NSW Government
Department of Planning and Infrastructure

Submitted electronically on 16/12/13

Sydney CBD and South East Light Rail Project – AFL NSW/ACT Commission Limited (AFL NSW/ACT) submission

Tramway Oval Baseline - Construction

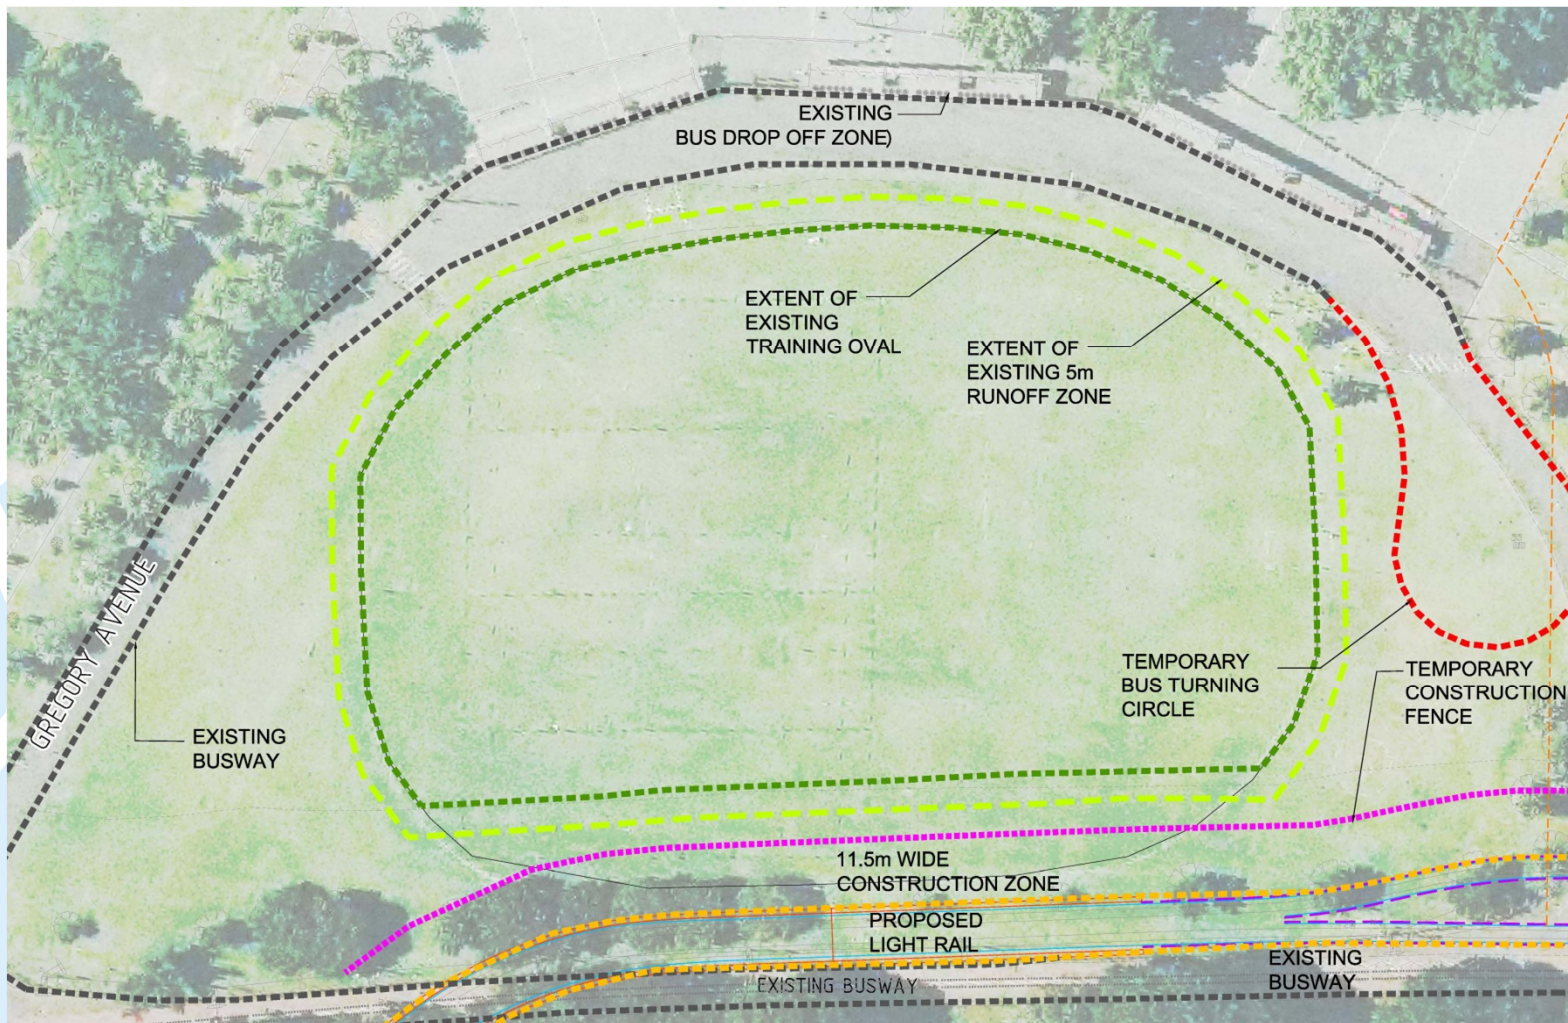
AFL NSW/ACT Limited recommends avoiding any loss of training oval width during construction, and can not accept any reduction in the width of Tramway Oval post construction.

- AFL NSW/ACT can not accept the width of Tramway Oval being impacted by 13 metres during construction, with a reduced training width remaining post construction.
- AFL NSW/ACT do not support the Bus Loop Event service road remaining as a daily Bus road post construction. This would isolate Tramway Oval inside a transport hub and significantly impact accessing the field and user safety during training – for both professional athletes and young children.
- AFL NSW/ACT would support extending the Oval to the east pre commencement of the CSELR Project in order to limit the construction zone footprint on the western boundary. The impact of a reduced training width (projected 7m) during peak construction would be offset by a slight increase in overall field width post construction (4.5m).

If the width of Tramway Oval is unavoidably impacted on the western boundary during construction, then AFL NSW/ACT recommend the eastern side of Tramway Oval be levelled and extended to the existing Bus Loop bitumen, gaining a minimum of 5 metres (potentially more). This will reduce any construction zone impact on the training oval width, and allow for continued AFL training during construction on this elite surface venue opposite the Sydney Swans training and administration base.
